From: Ian Stocks [REDACTED] half Of FRS Water and Access

Subject: Planning consultation - BN/114/21/PL Land to rear of Highground House & Orchard End, Highground Lane Barnham

Figure 2. Development layout plan of the proposed new dwelling and paved driveway. RPS Design Group. [05/03/2021].

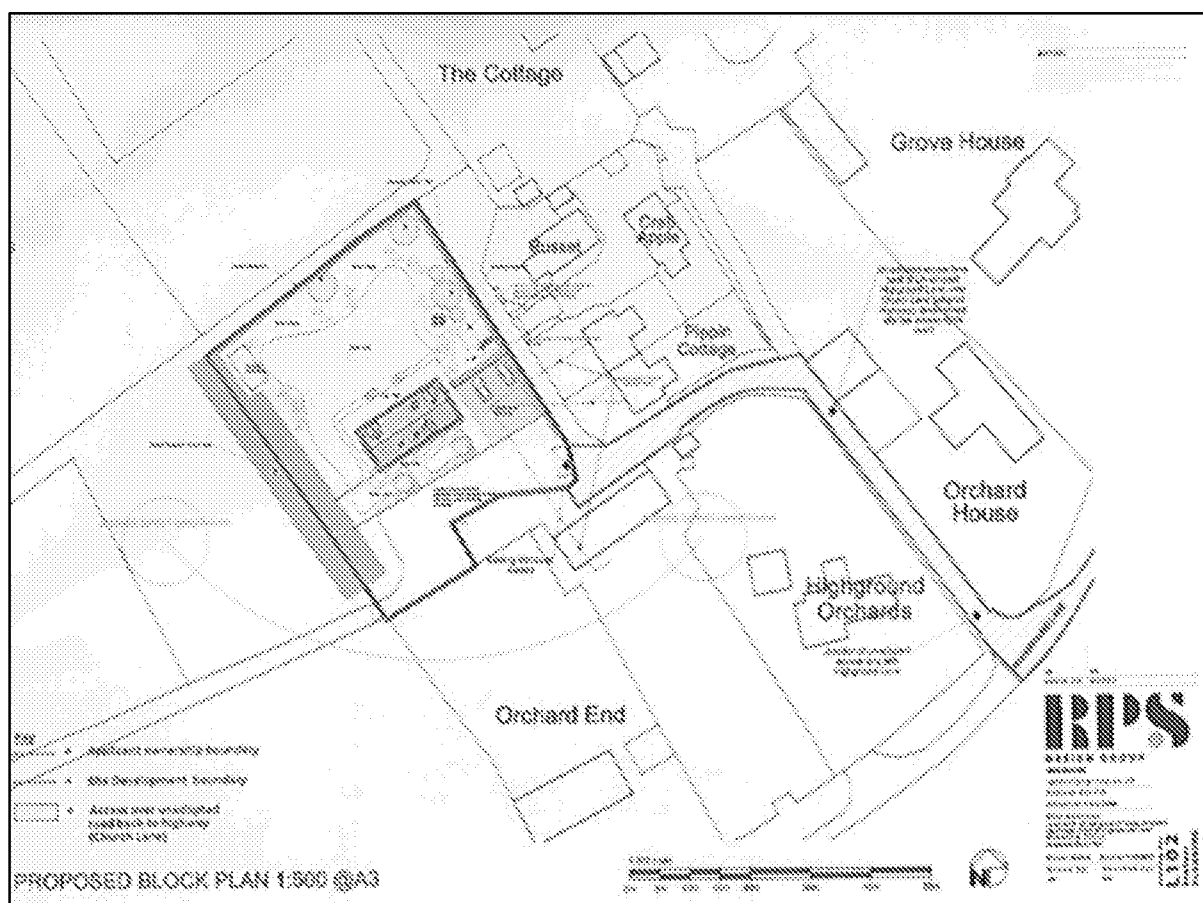
The access route to the new dwelling will also need to comply with AD-B Volume 1: B5 section 13, the access road needs to be 3.1 metres between a gateway and 3.7 metres between curbs, it is unclear from the plans submitted if the required access width for a fire appliance has been achieved, sections of the access road look to be too narrow which would prevent the fire appliance gaining access in an emergency.
